Please upload the above except drawings 6797-PL-024E and 6797-PL-023E since they should be amended again.
The Action Sheet follows.

Please find amended plans addressing the concerns raised in our numerous correspondence. The key amendments are as follows:

Proposed South Elevation (C)

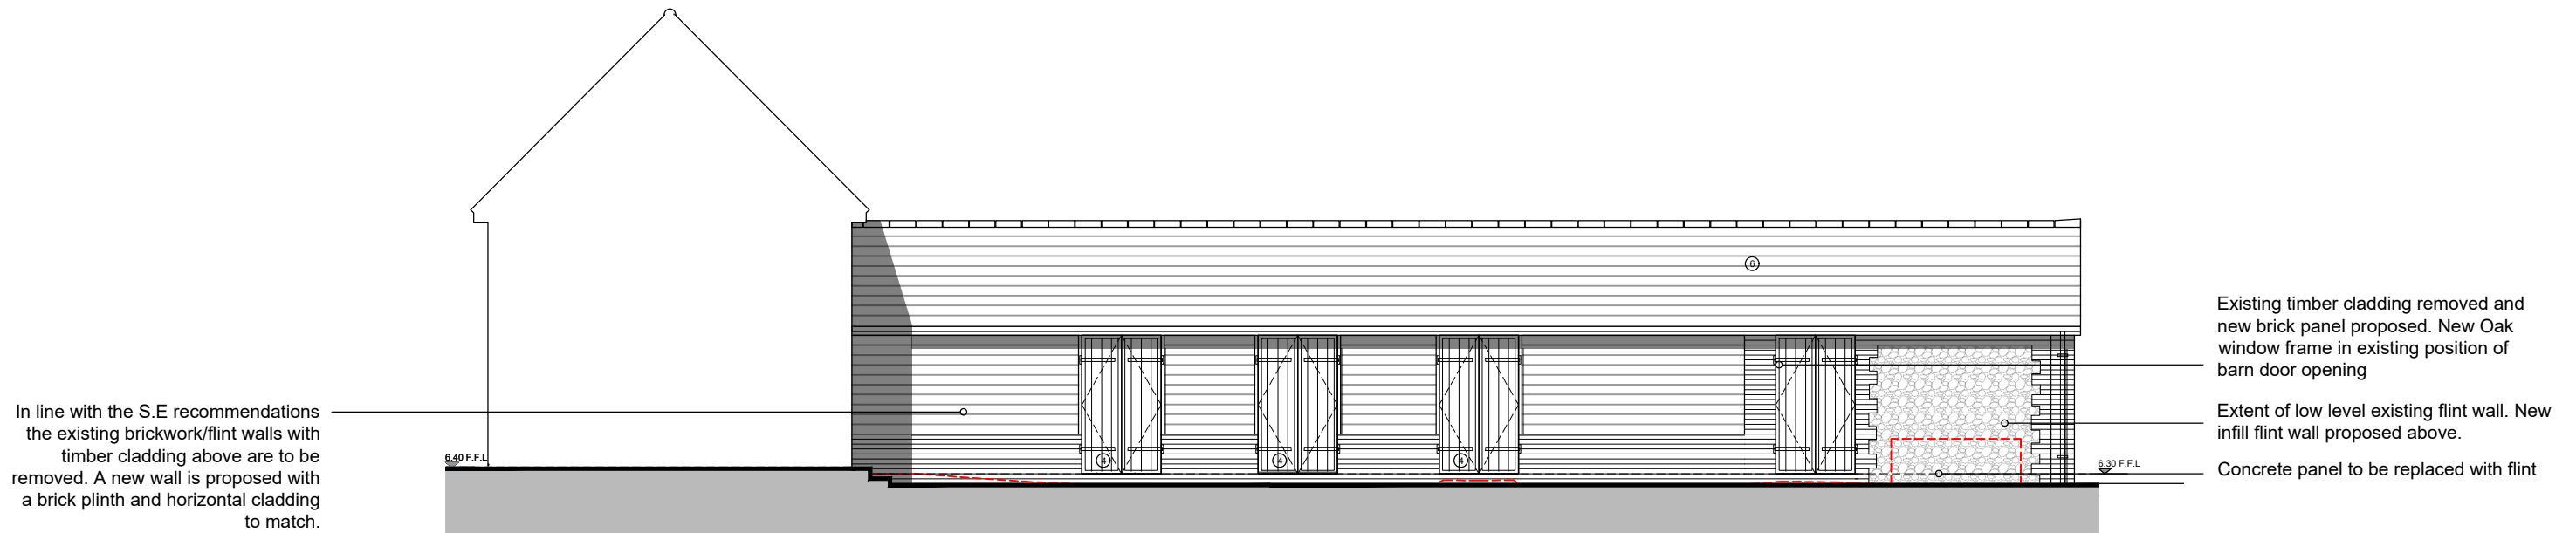
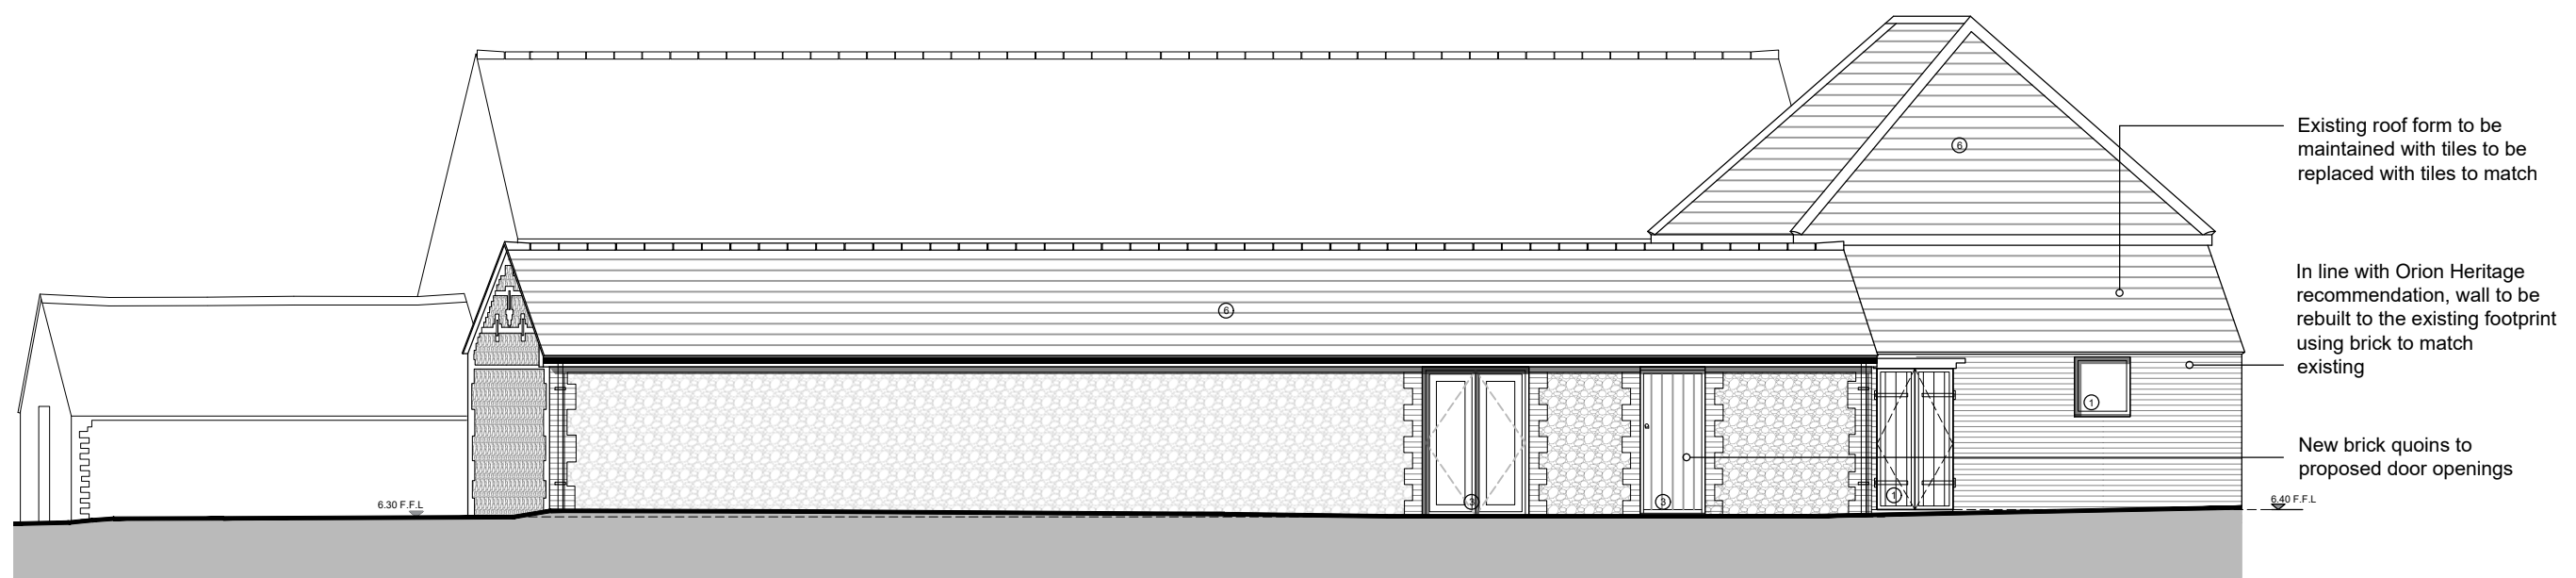
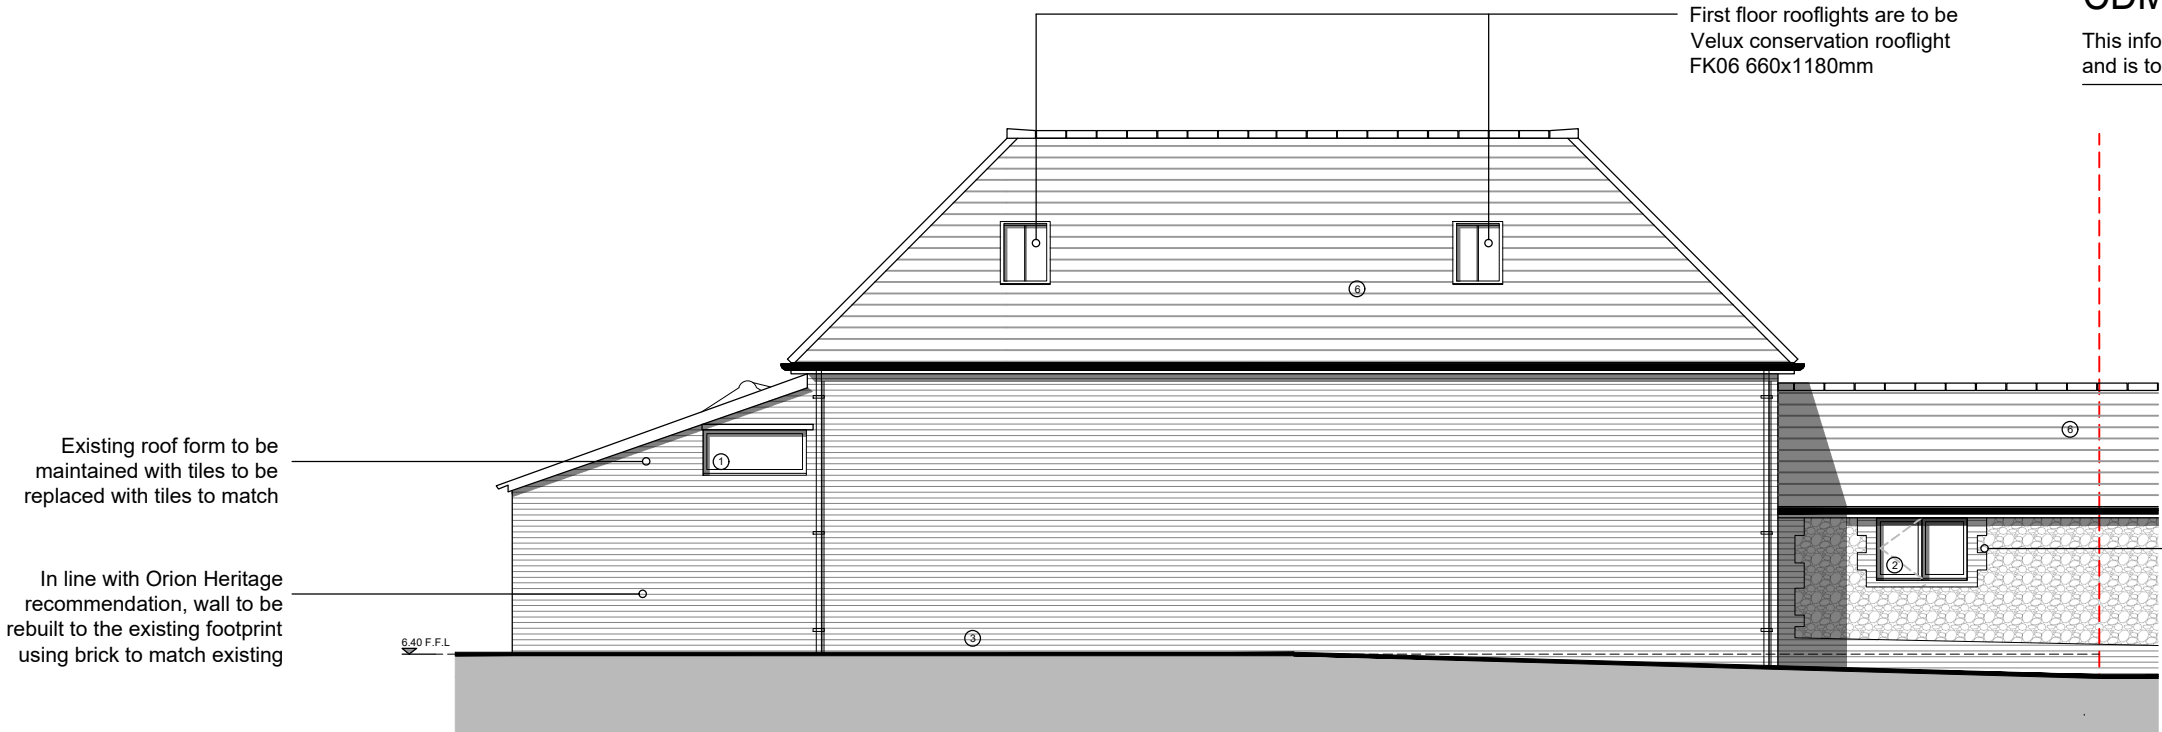
- Amount of conservation rooflights reduced to just two (one per bedroom) located on less prominent north western elevation.
- South elevation amended so size and position of new windows and doors reflect existing.

Proposed South Elevation (B)

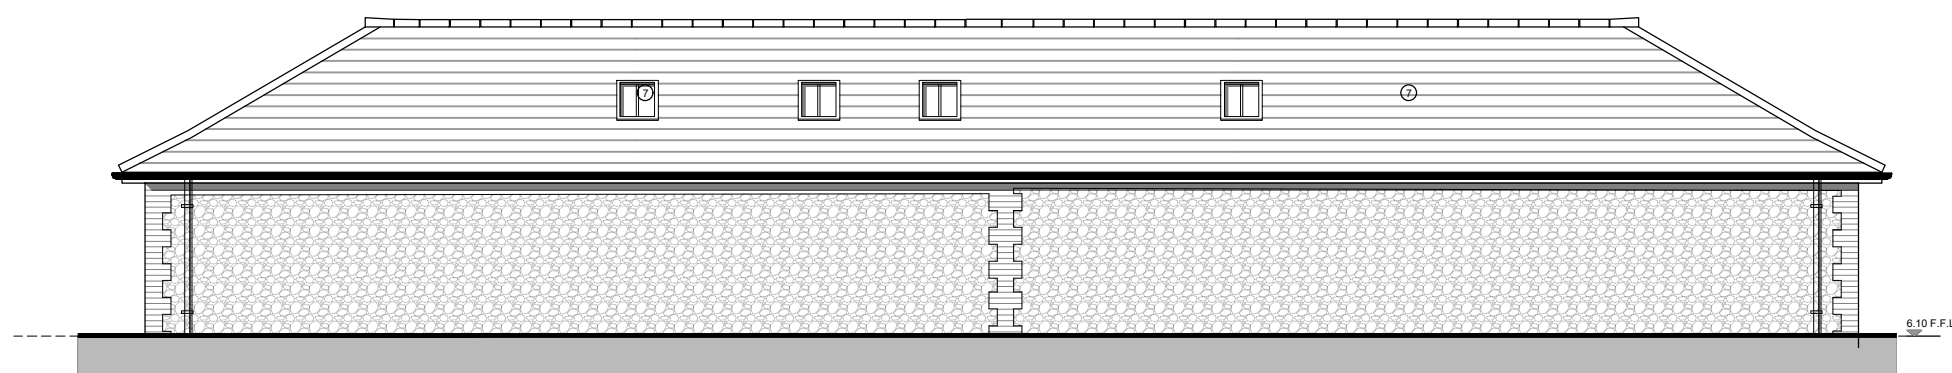
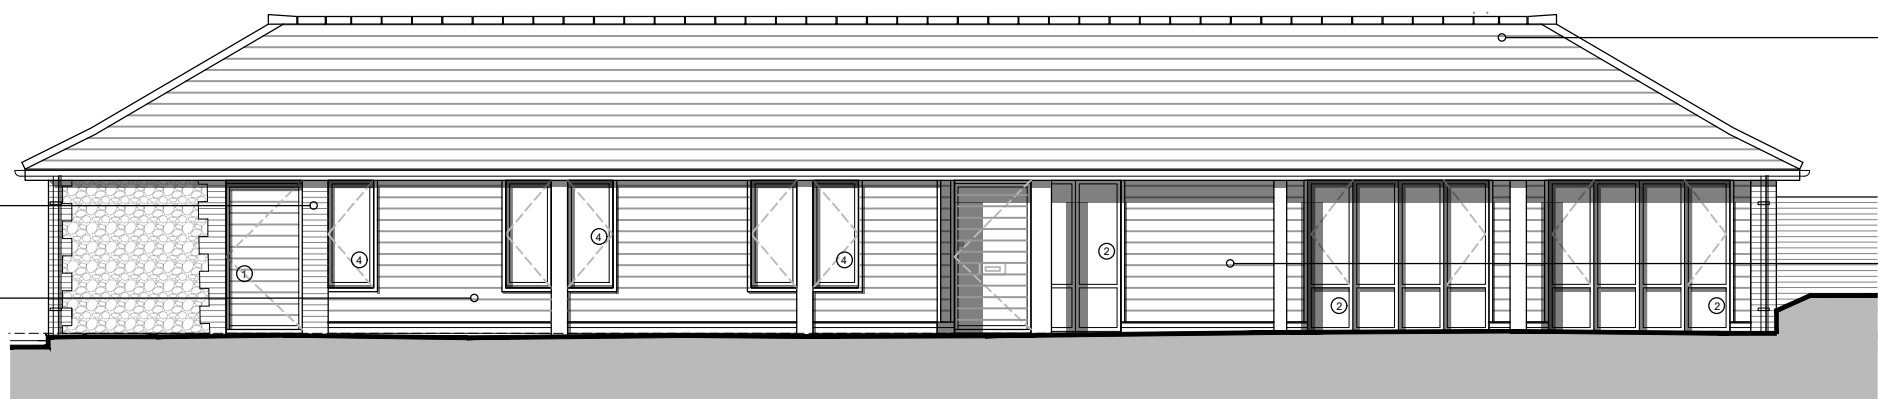
- Windows on east elevation of single storey element reflect the existing openings as closely as possible.
- South elevation – the size/number of doors on the south elevation have been reduced in size to reduce the impact as far as possible whilst allowing access to the courtyard.
- North elevation – the number of rooflights has been reduced as per our telephone conversation in early April.
